From: Laura Gibbons
Sent: 02 January 2019 14:05
To: Planning.Responses
Cc: Michael Eastham
Subject: RE: Planning Consultation on BN/59/18/DOC

Engineers Comments Regarding Condition 5 and 6

APPLICATION BN/59/18/DOC
NO:

Description of Works: Approval of details reserved by condition imposed under ref APP/C/3810/A/13/2193942 relating to Condition No 5 surface

Title: **Private Drainage Layout Sheet 2 of 3**

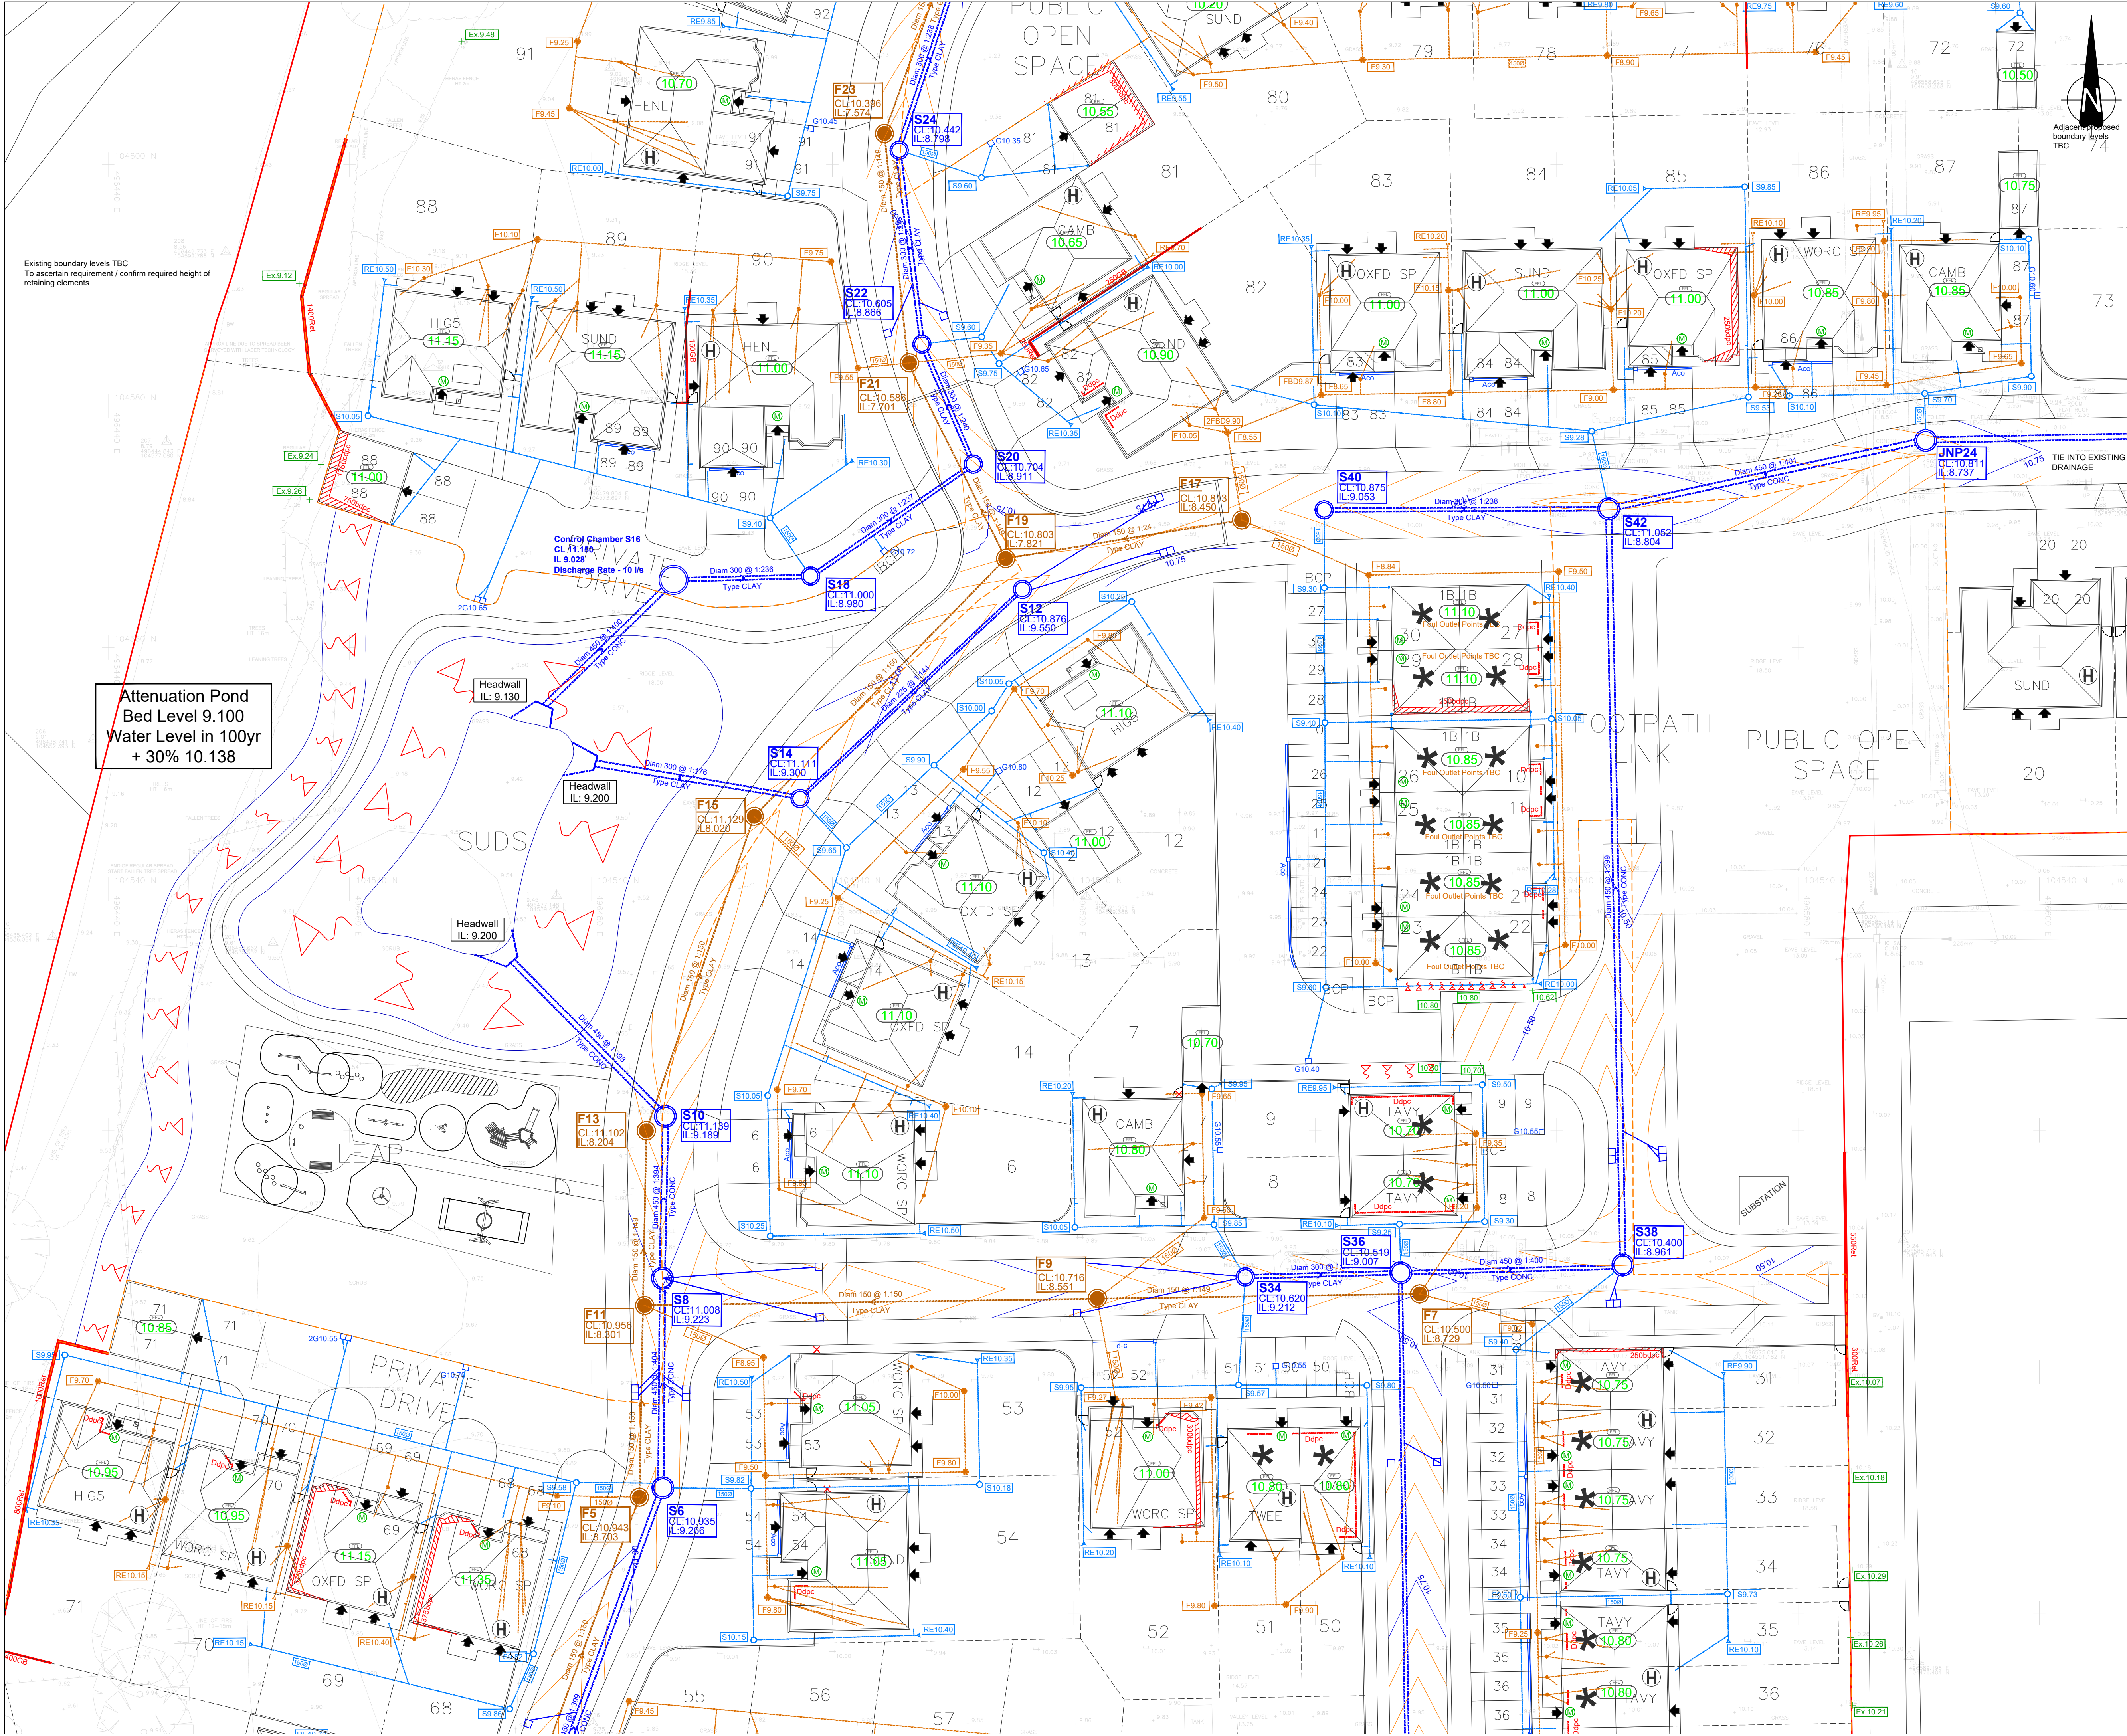
Please can the drainage layout and details drawings, maintenance manual etc. be updated to include the drainage originating from the rear of the retaining walls.
